**Planning Application No: S6/2008/2412/FP**

**Proposal: Two Storey Rear Extension, First Floor Rear Bay Window & New Garage**

**Location: 65 Pine Grove, Brookmans Park, Hatfield, Herts. AL9 7BL**

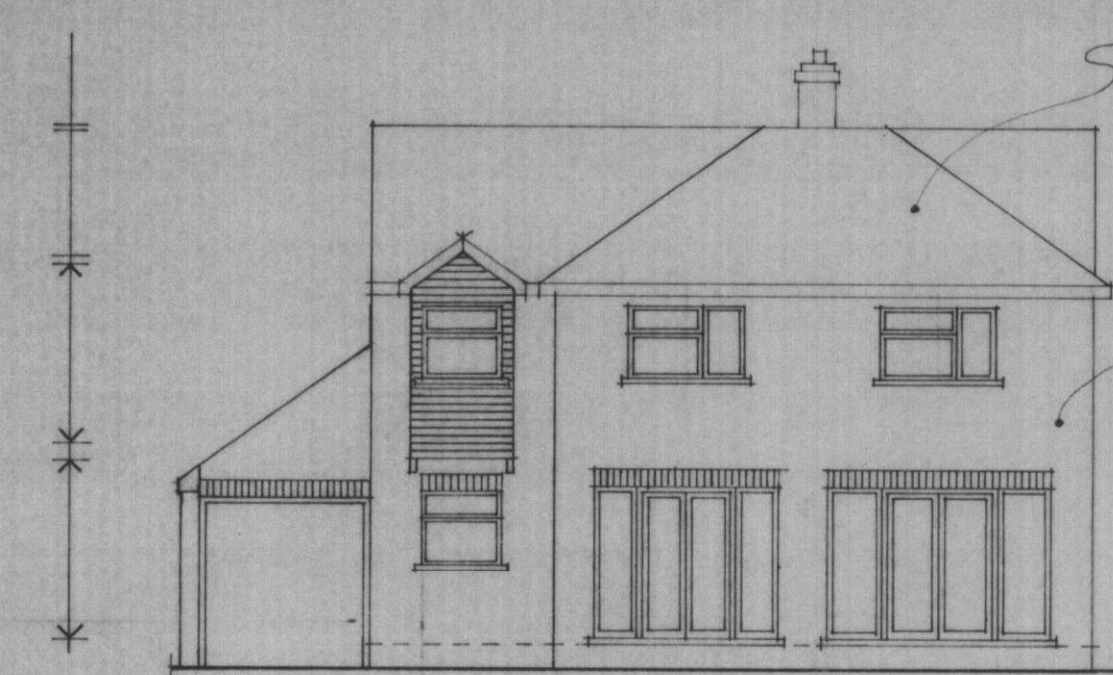
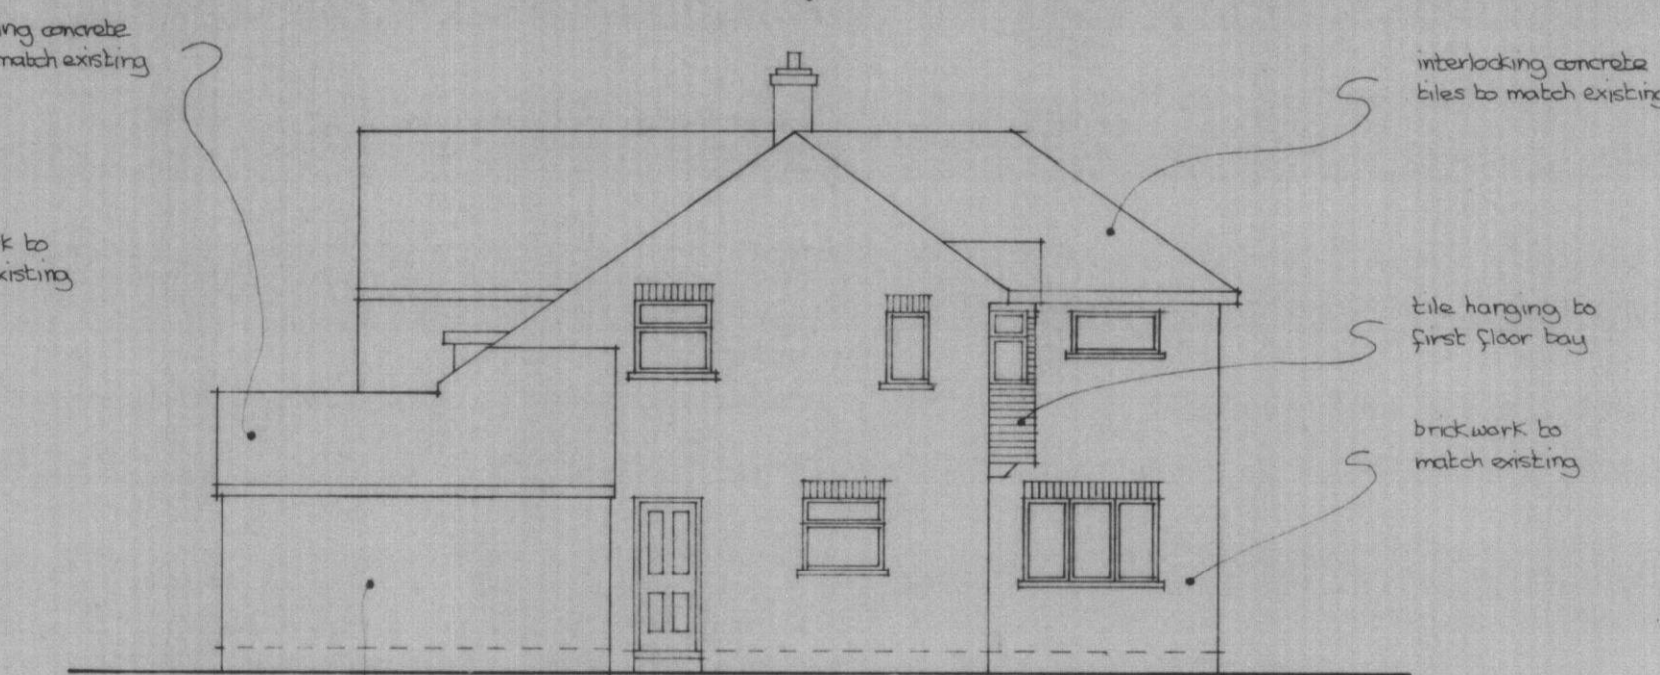
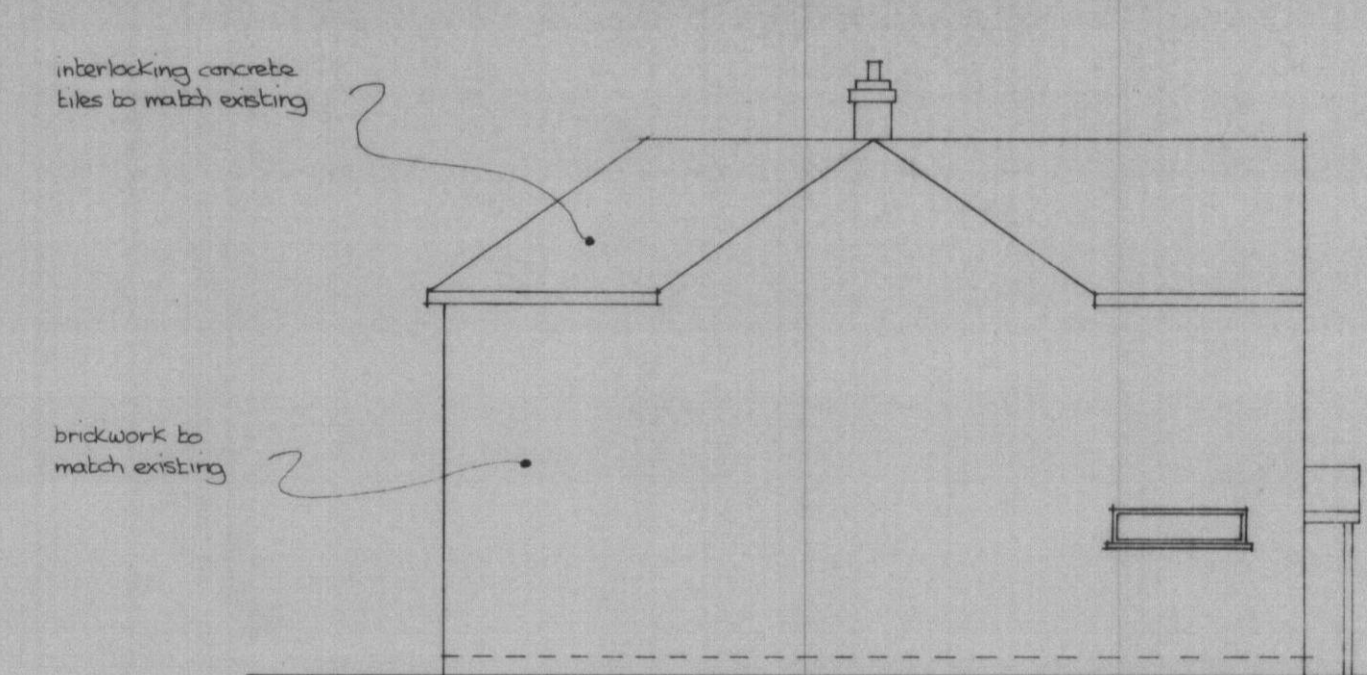
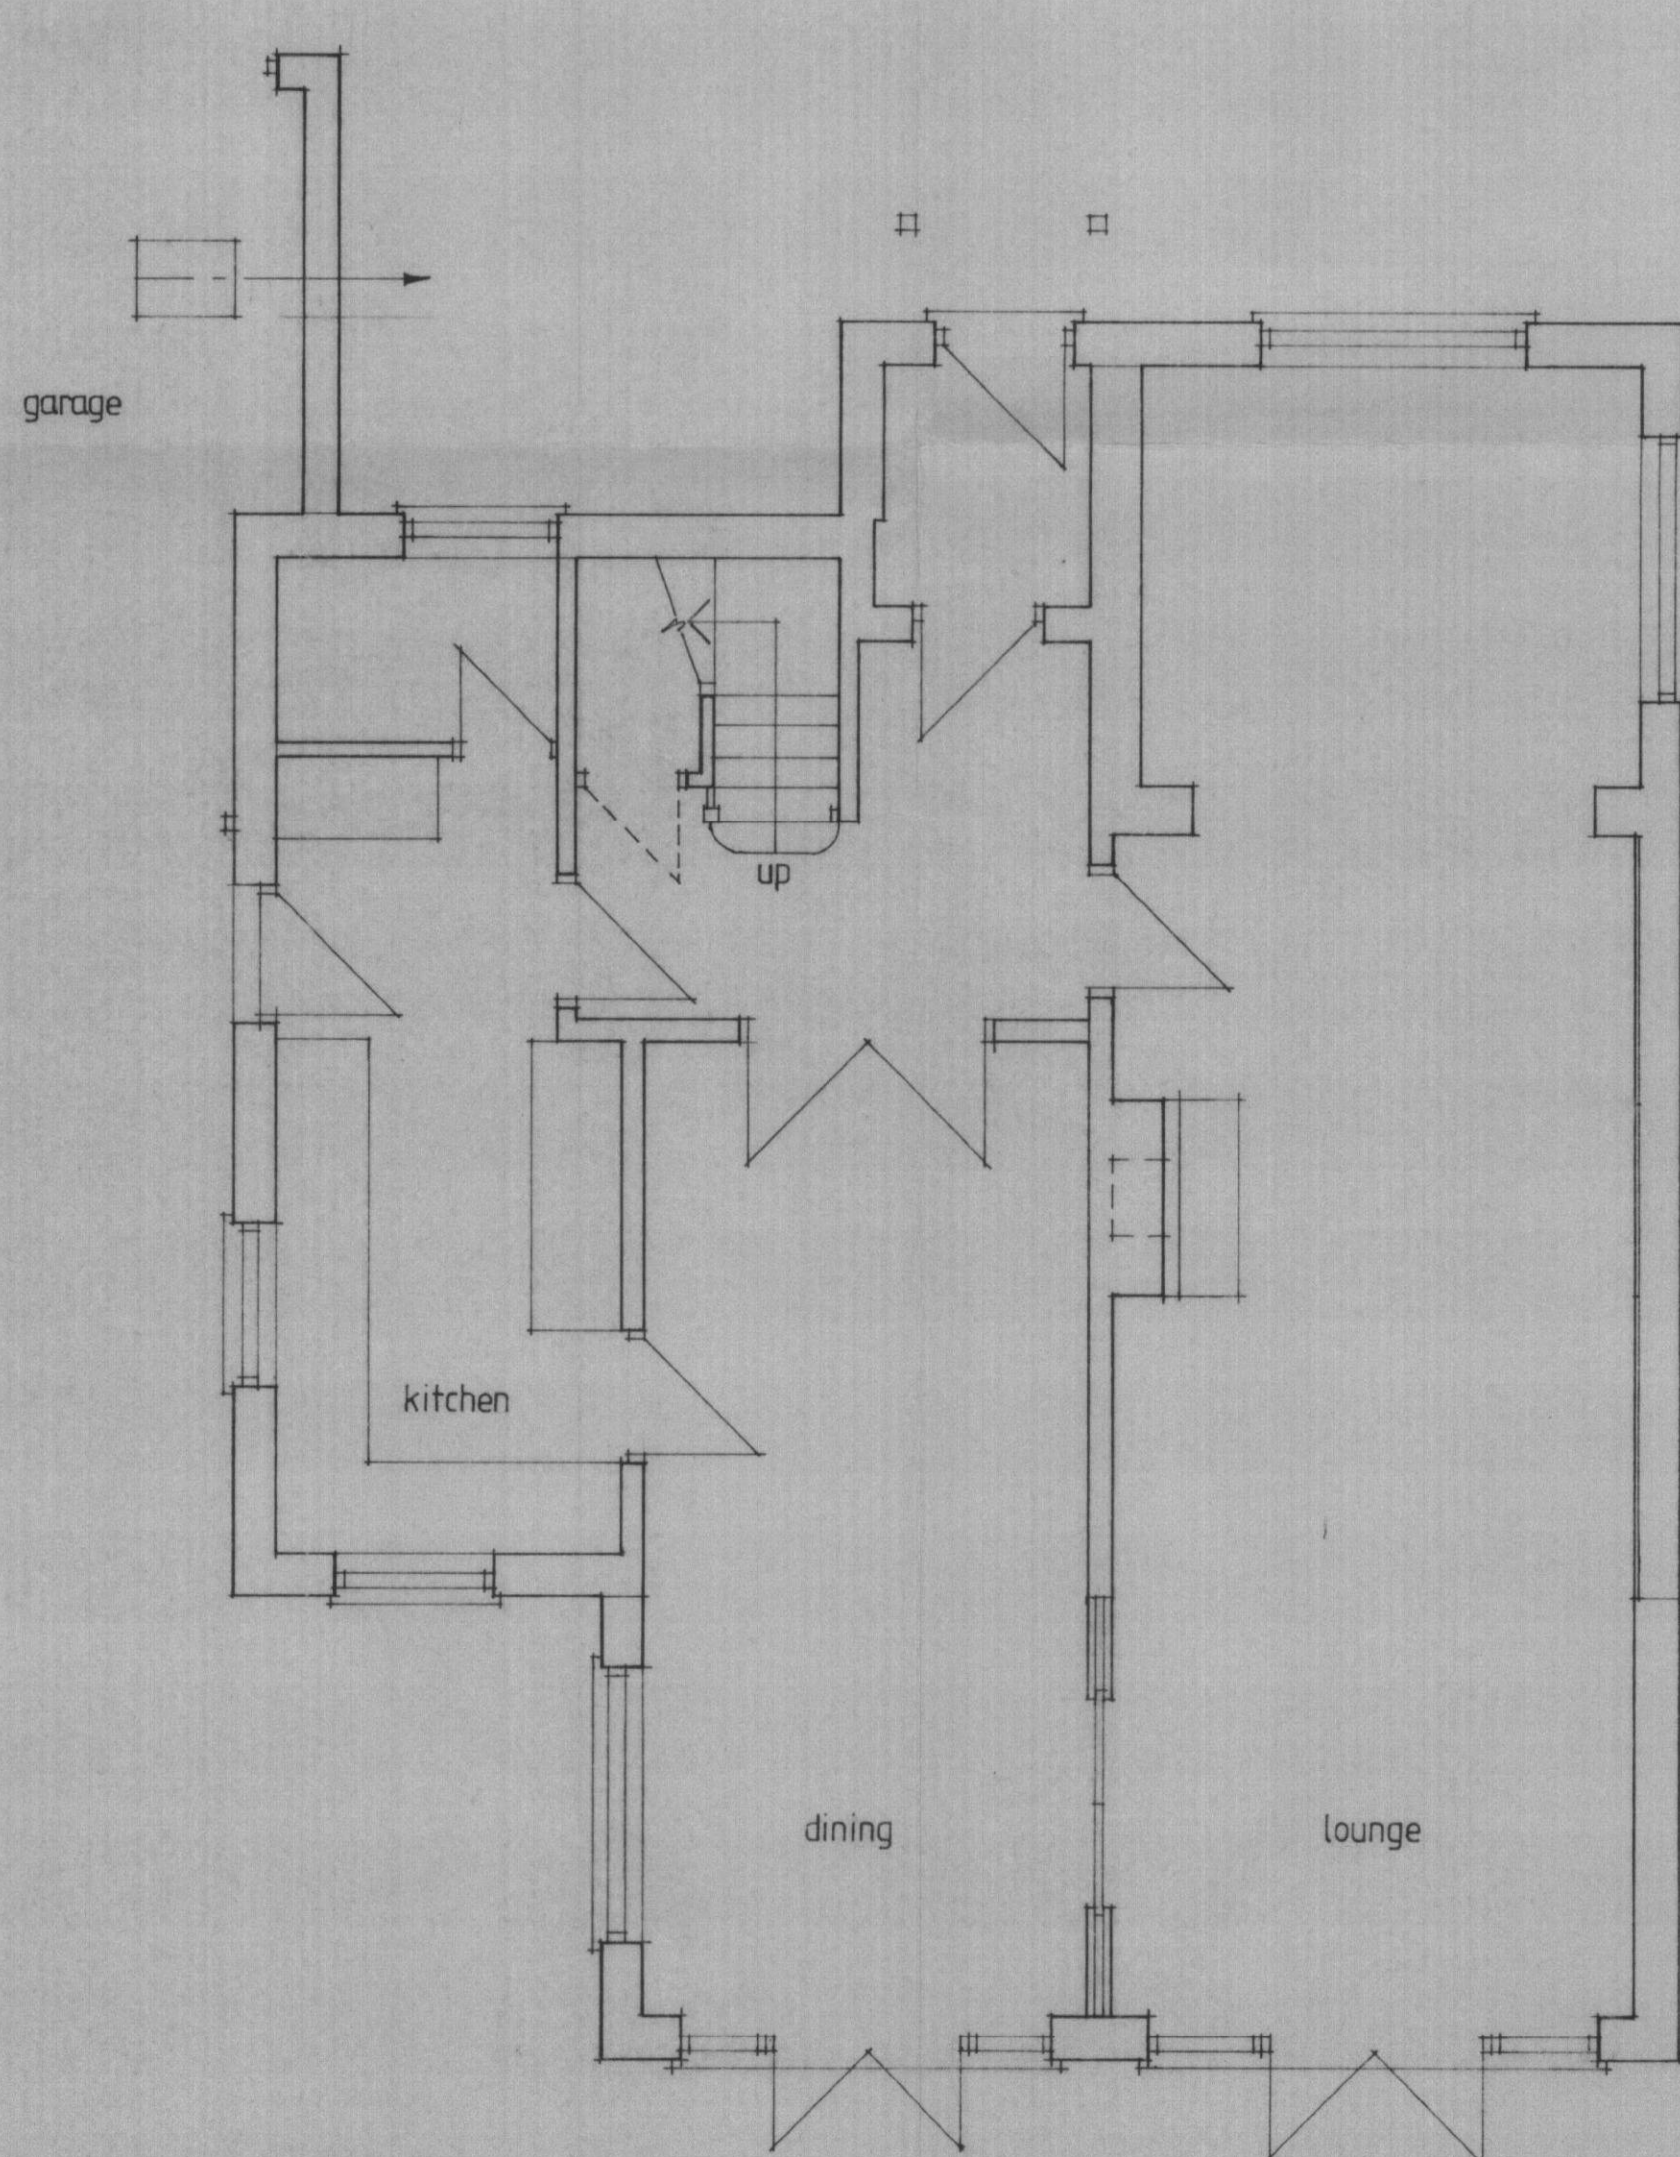
Thank you for giving my Client the opportunity of amending the drawings in order to obtain planning permission. I enclose 2 copies of drawing no. 0801/03C showing the garage reduced in size at the front of the house, all to your requirements.
